**MEMORANDUM**

**RE:** Traffic Memorandum for Latigo Preserve Filing No. 10  
El Paso County, Colorado

CONESTOGA TRAIL SOUTH ACCESS AT EASTONVILLE ROAD  
SIGHT DISTANCE EXHIBIT

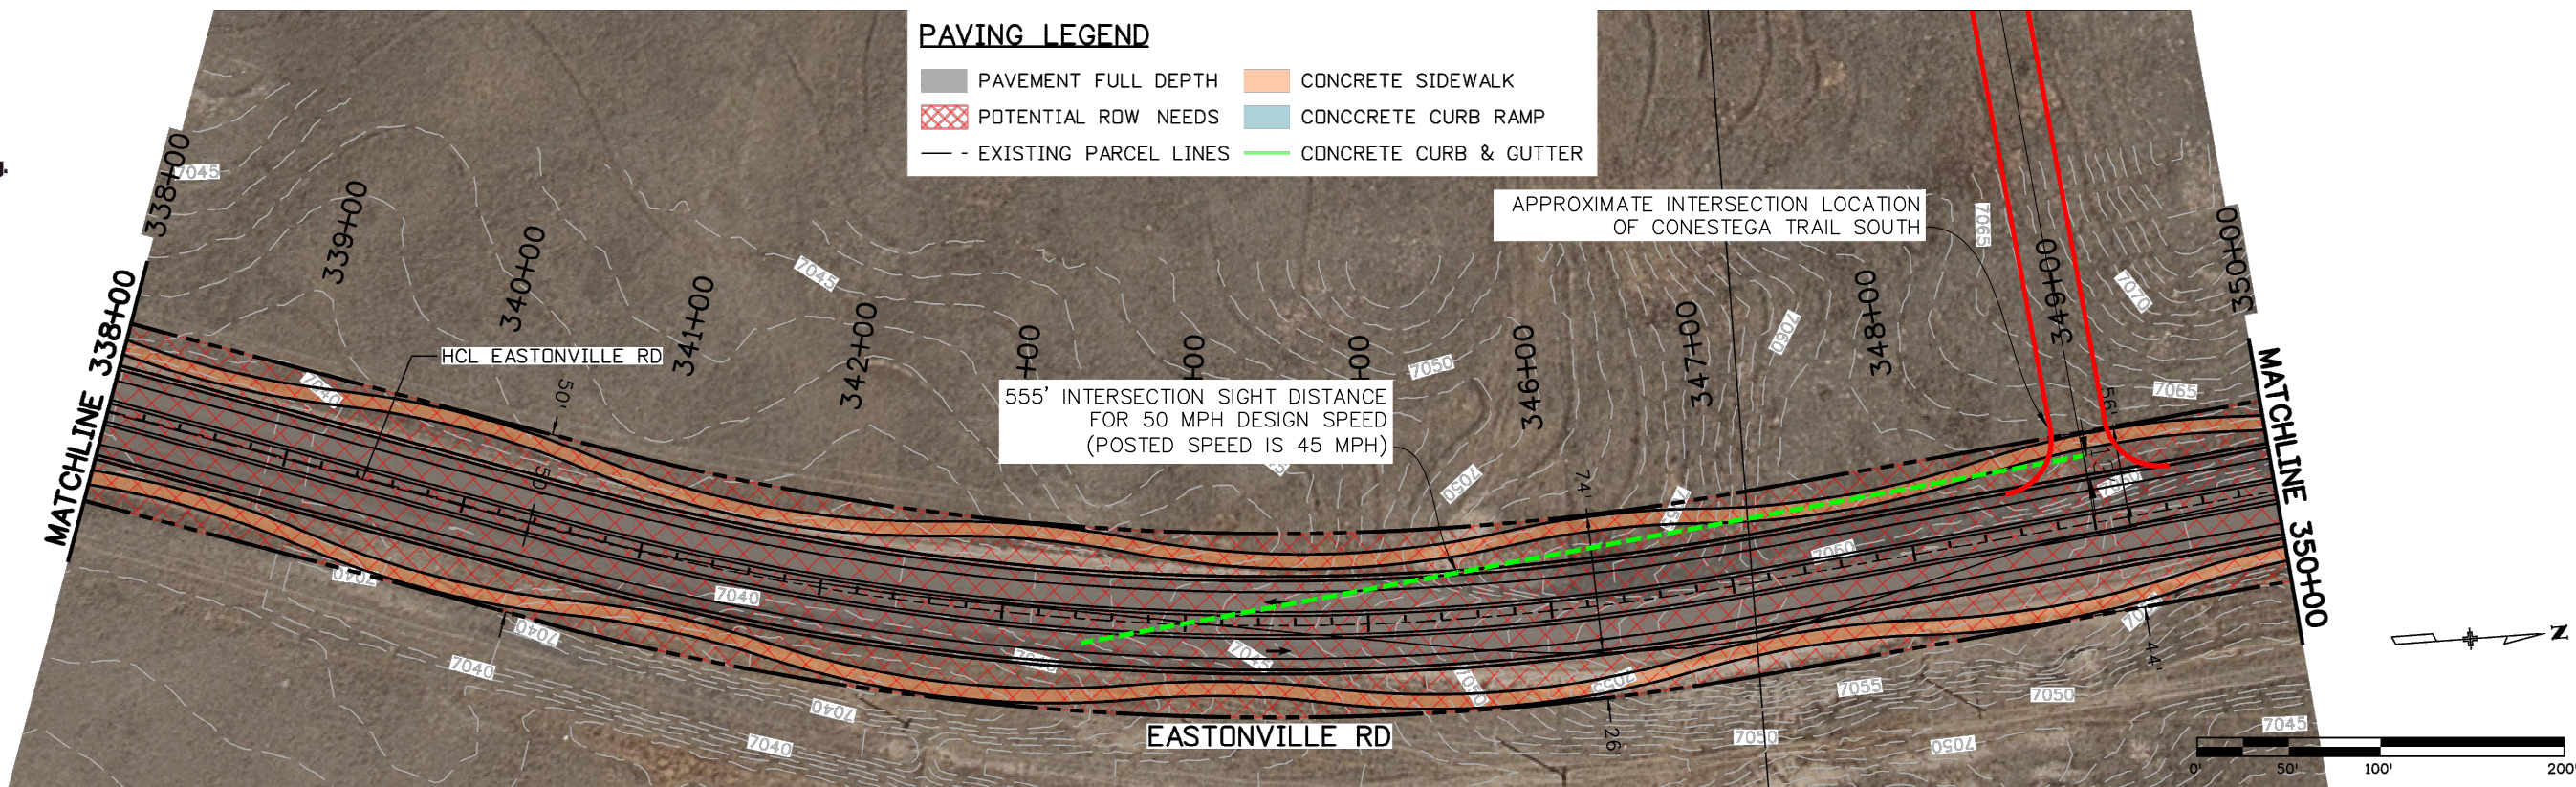
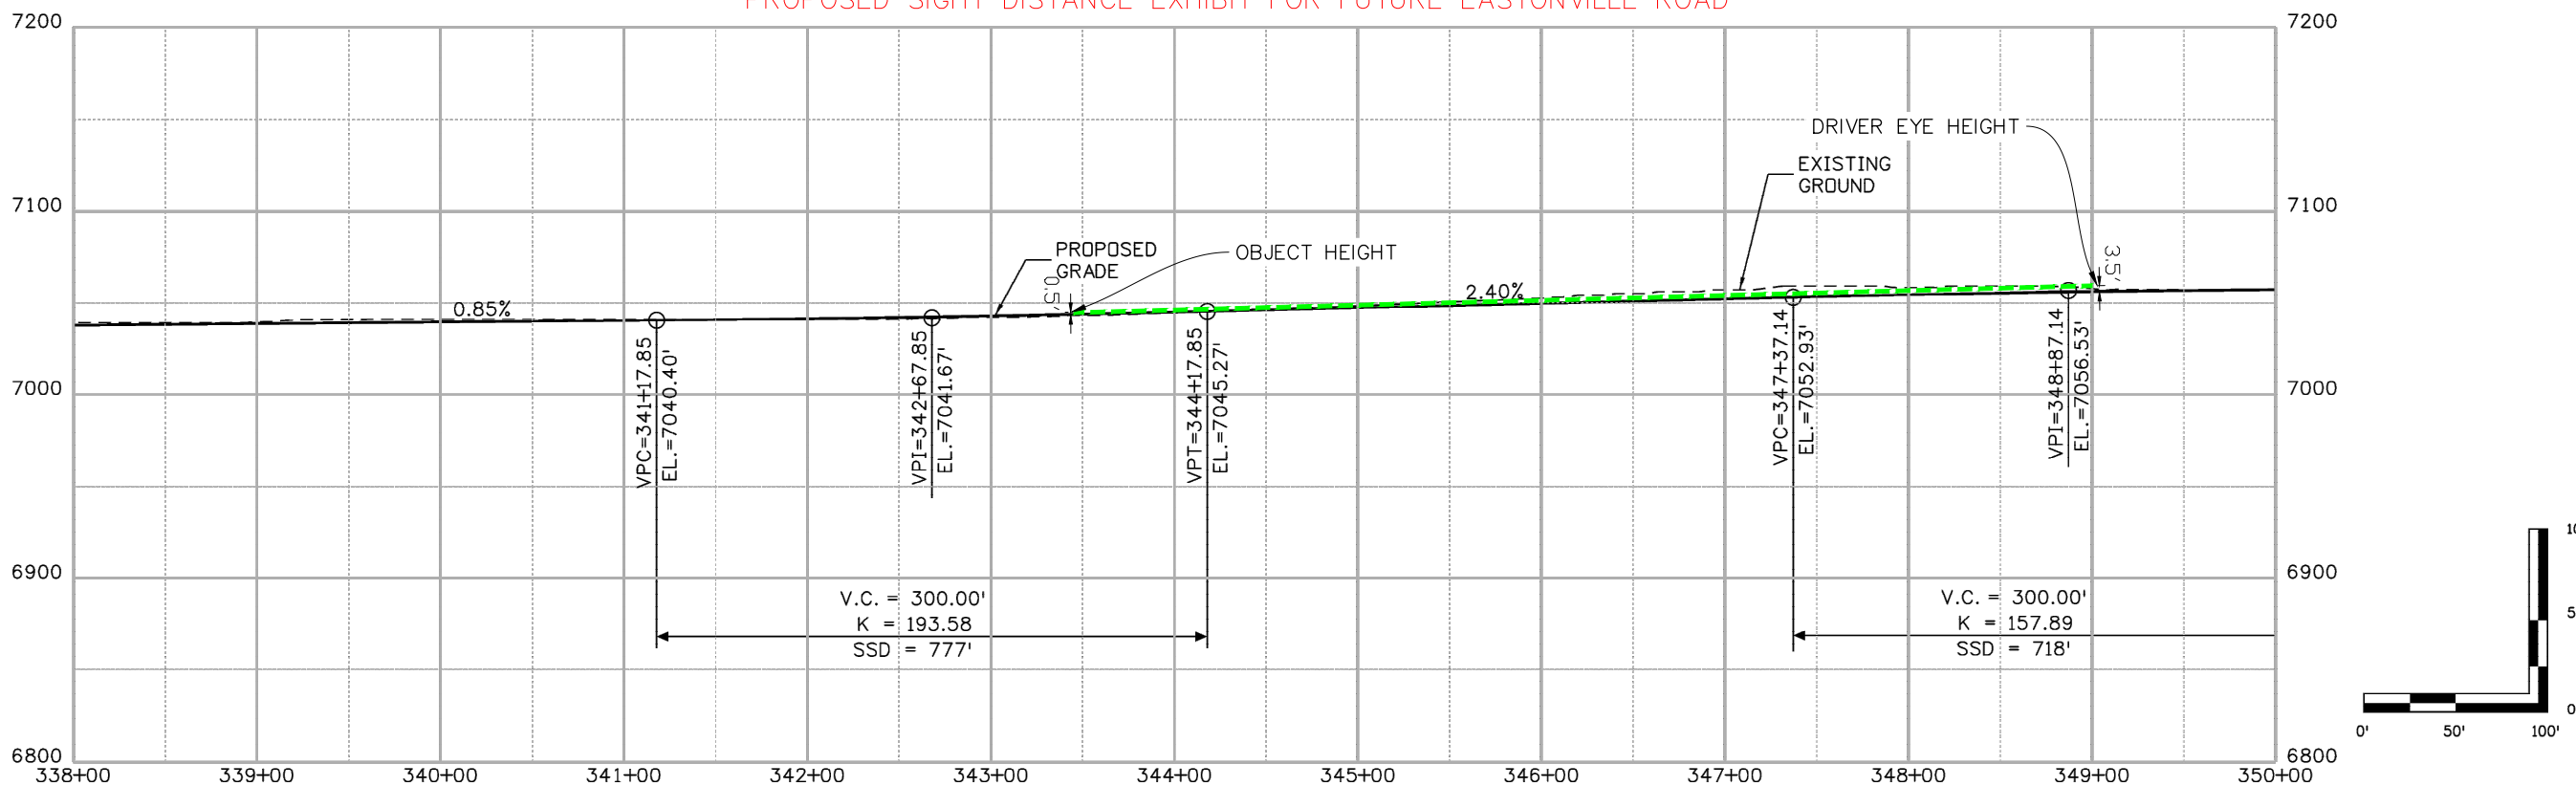
Please include figure of sight distance.
